Re: Fastino's, 3723 4th St. NW, Traffic Circulation Layout

Architect's Stamp dated 09-02-11 (G-14/D075)

Based upon the information provided in your submittal received 09-02-11, the above referenced plan cannot be approved for Building Permit until the following comments are addressed:

Traffic Circulation  
Layout

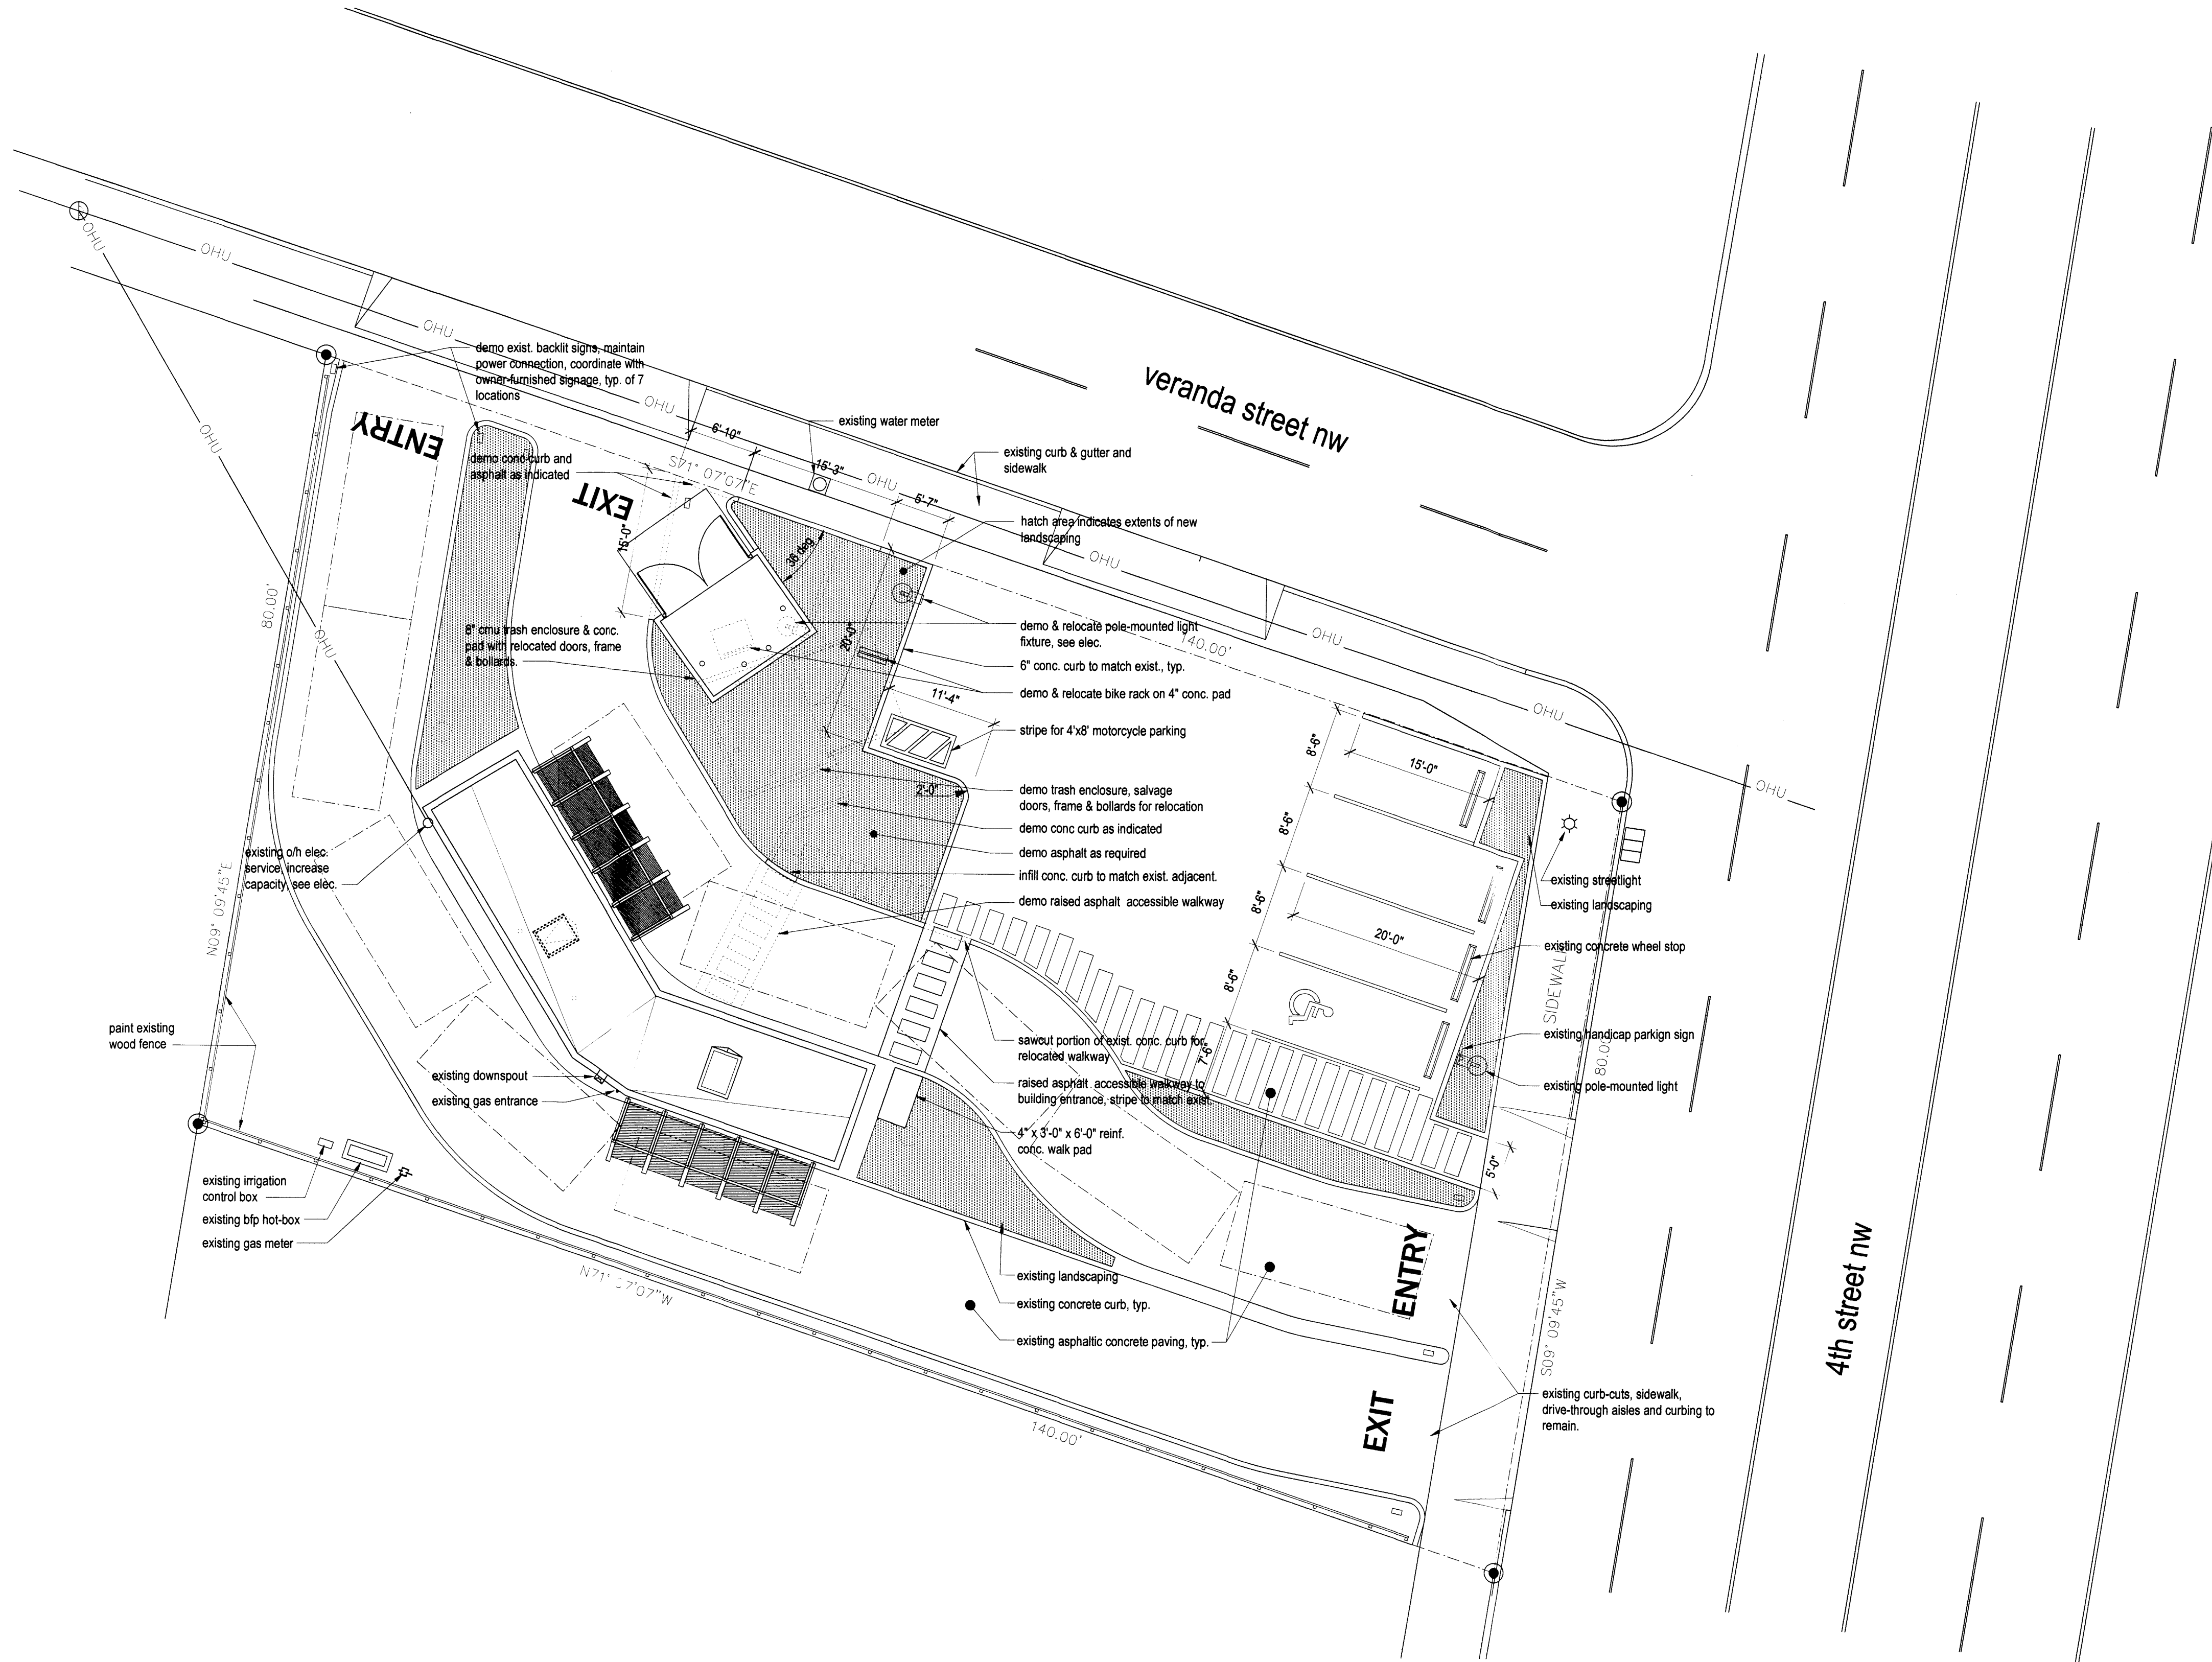
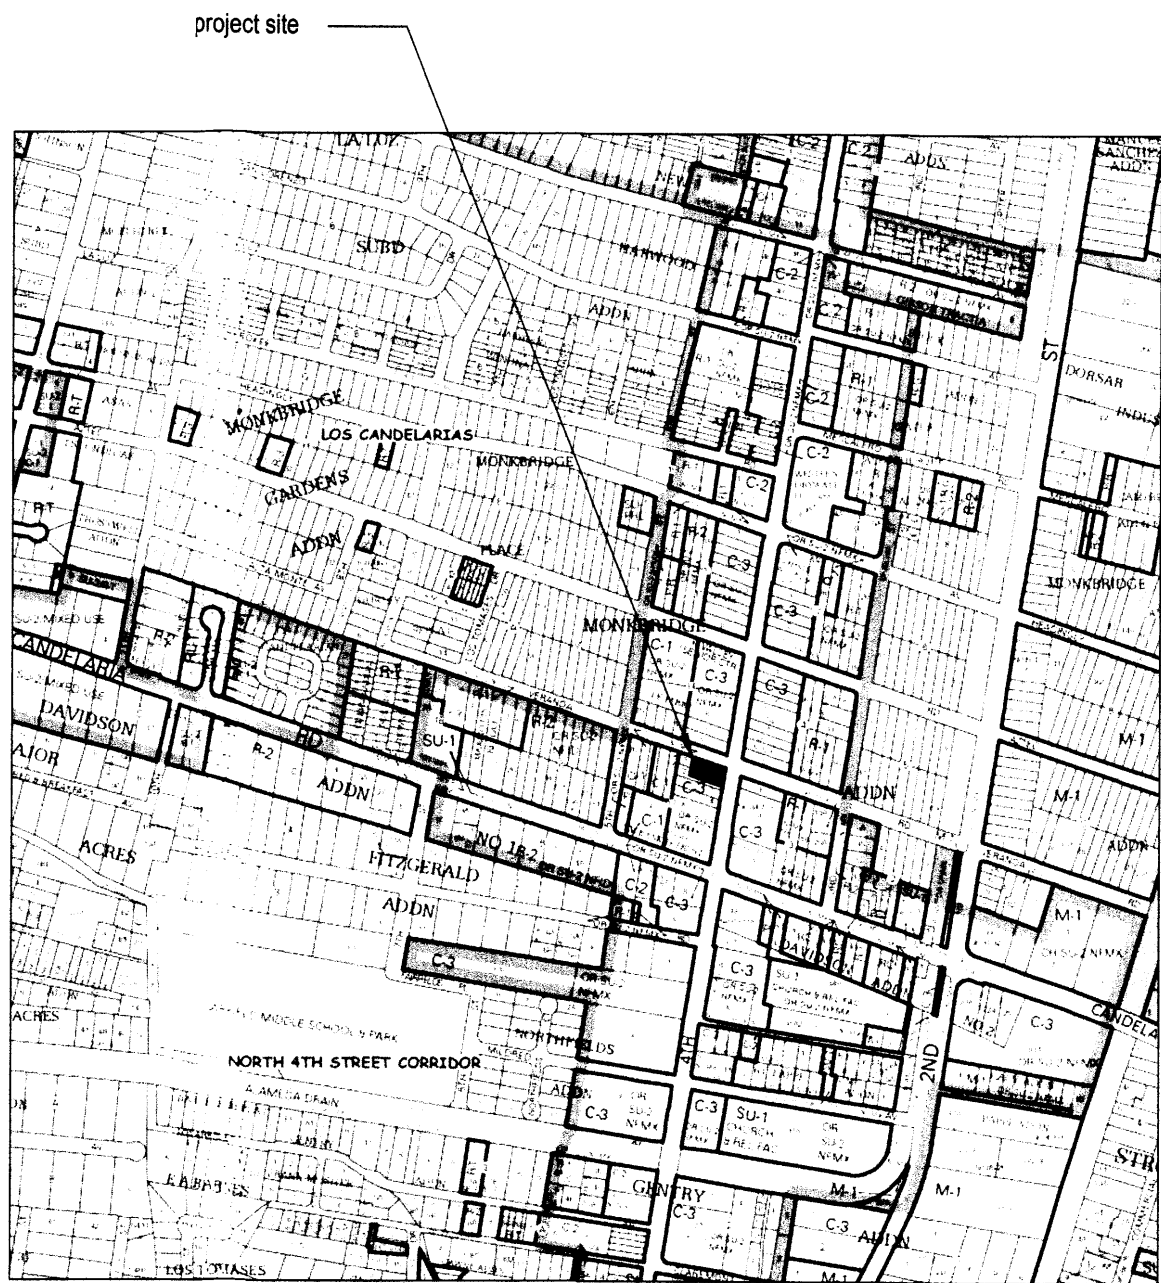
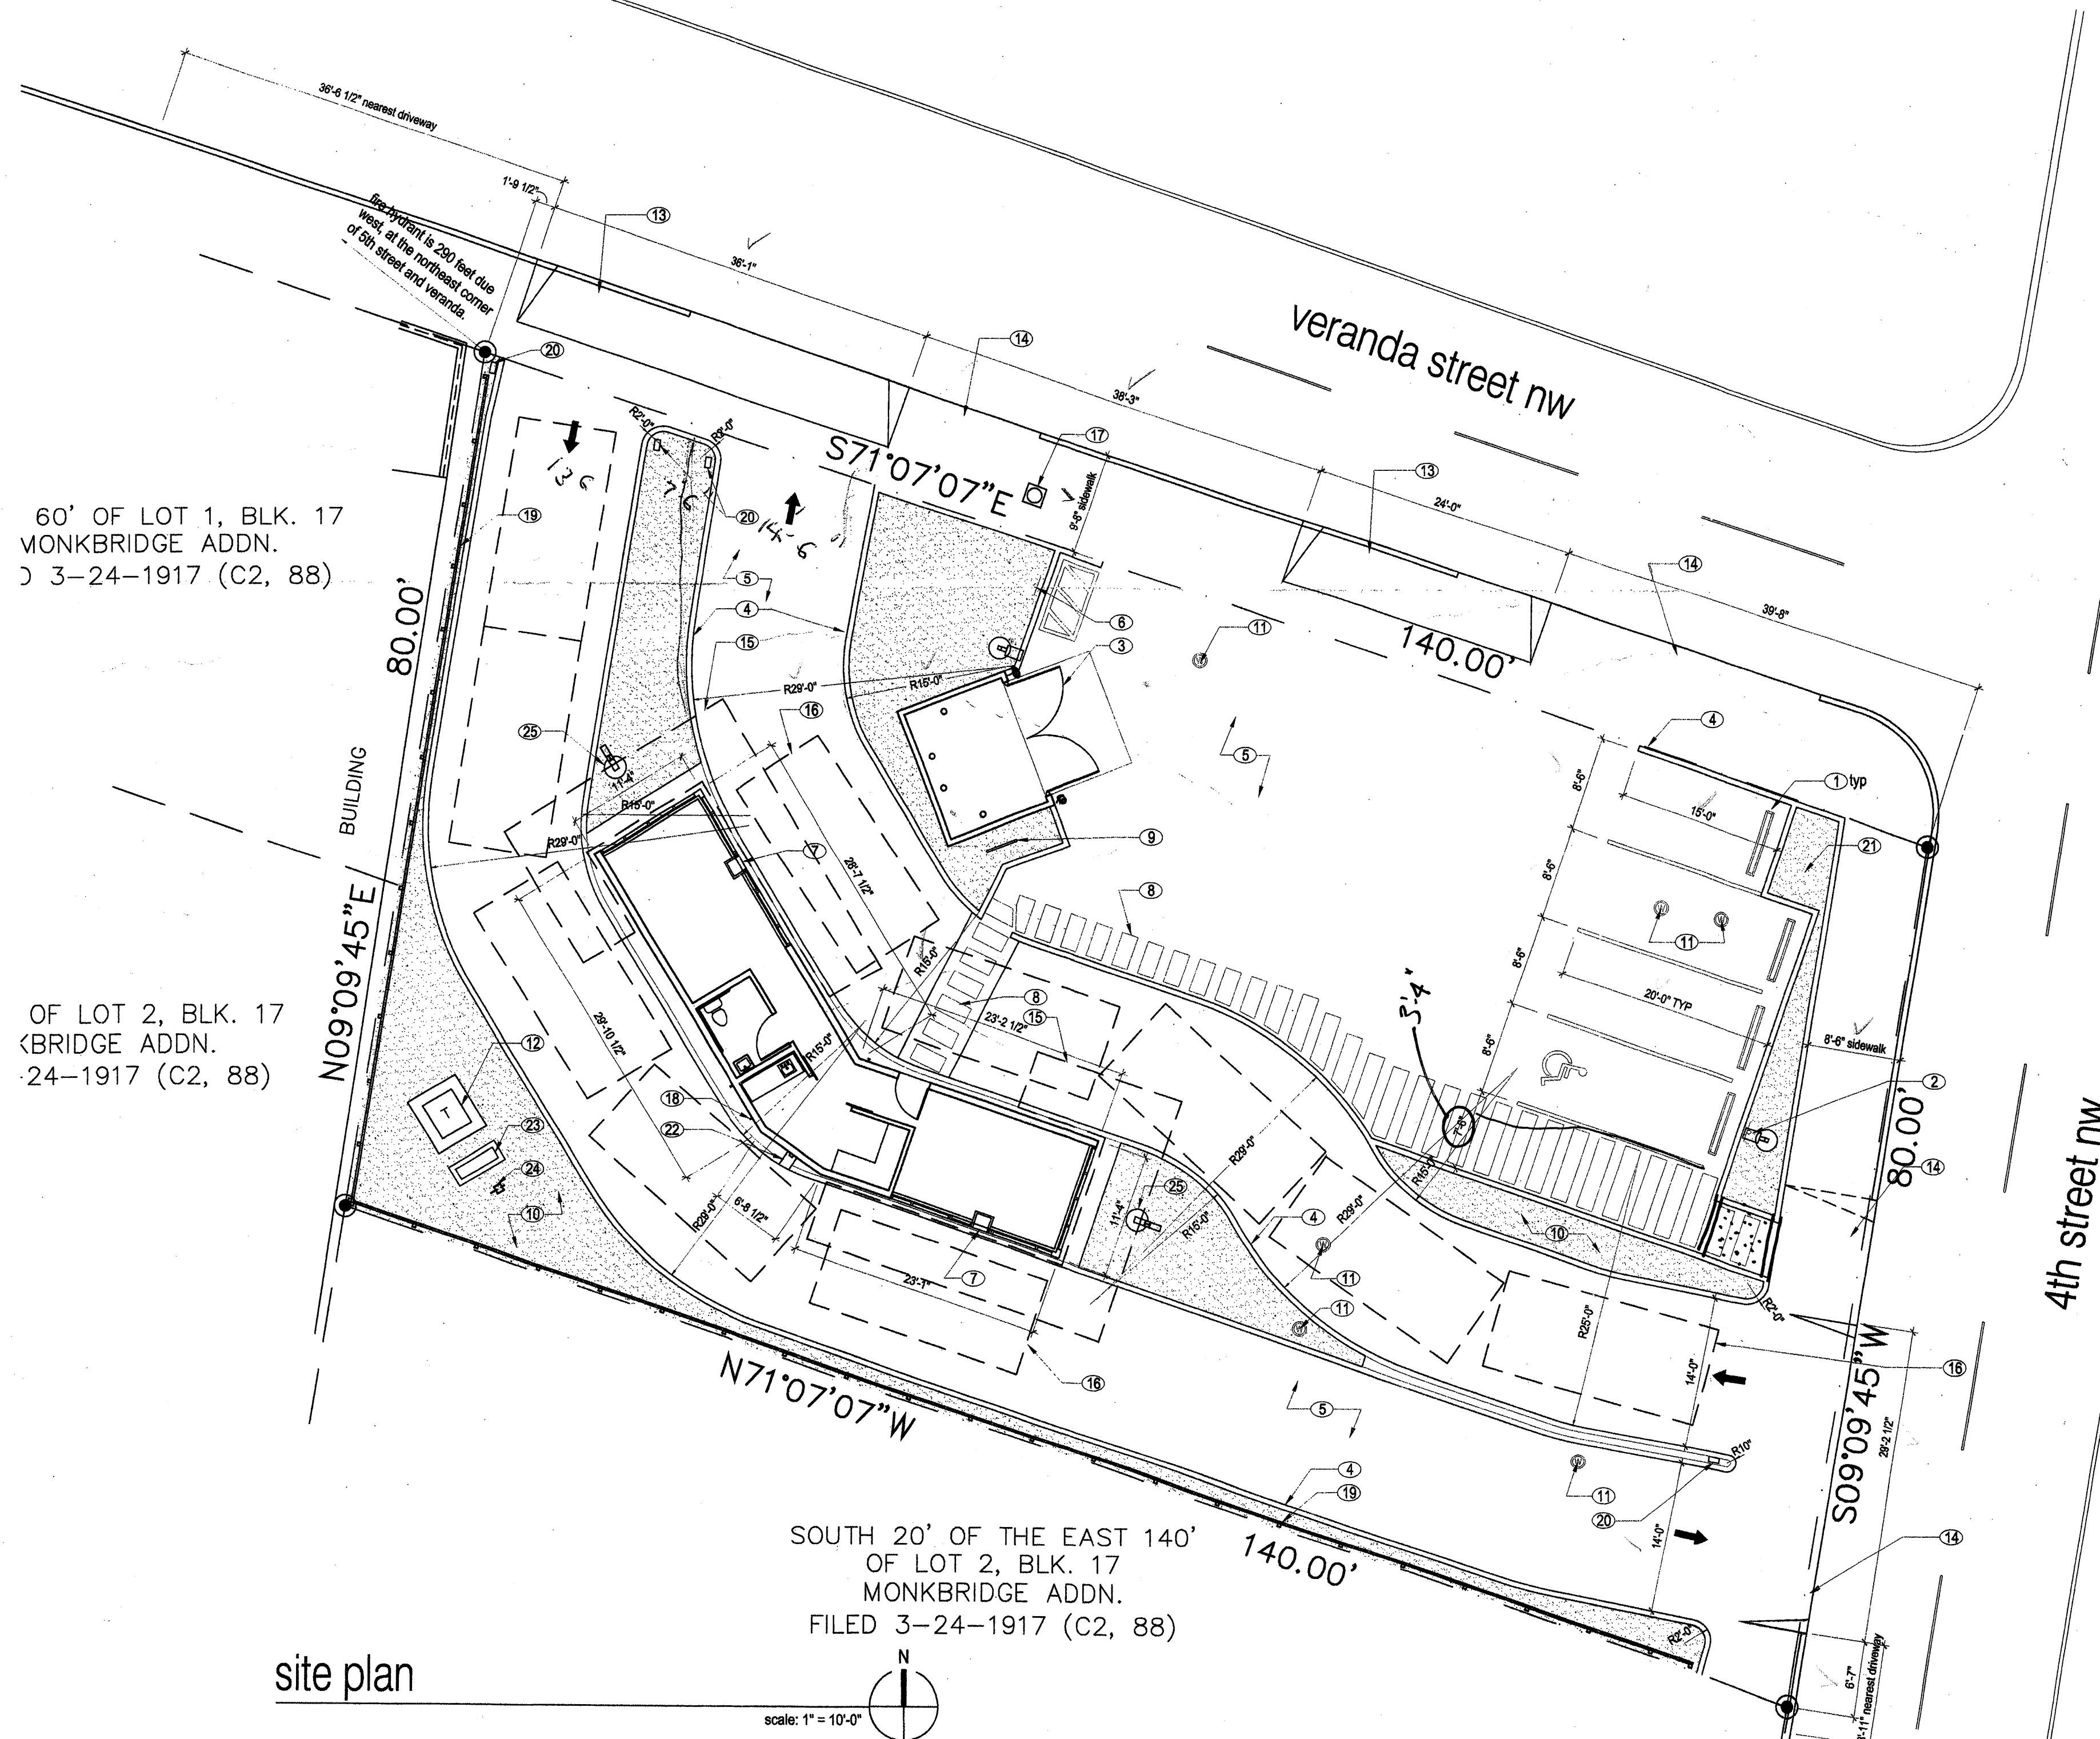
- Please clarify how Solid Waste will empty the dumpster. It appears that the truck will have to drive the wrong direction in the one-way drive.
- 2. Solid Waste approval is required for the relocation of the dumpster.

- 3. Provide additional information regarding the drive through aisles. Are the drive throughs separate, or do they function as one drive through?
- 4. The dumpster must drain to a sanitary sewer connection (see the *Development Process Manual*, Chapter 23, Section 9). Coordination with Hydrology is required.

- 5. Please clarify all existing versus proposed conditions.
- 6. List radii for all curves shown.
- 7. Define width of the existing sidewalk.
- 8. A six-foot wide pedestrian connection is required to 4th Street.

- 9. Identify the width of all drive pads.
- 10. Provide one way signing and striping for all proposed one-way aisles.
- 11. Label the compact parking spaces by placing the words "compact" on the pavement of each space.

- 12. At the corner of Veranda Street and 4<sup>th</sup> Street, is the wheelchair ramp ADA compliant?
- 13. Is there a median break at the site?
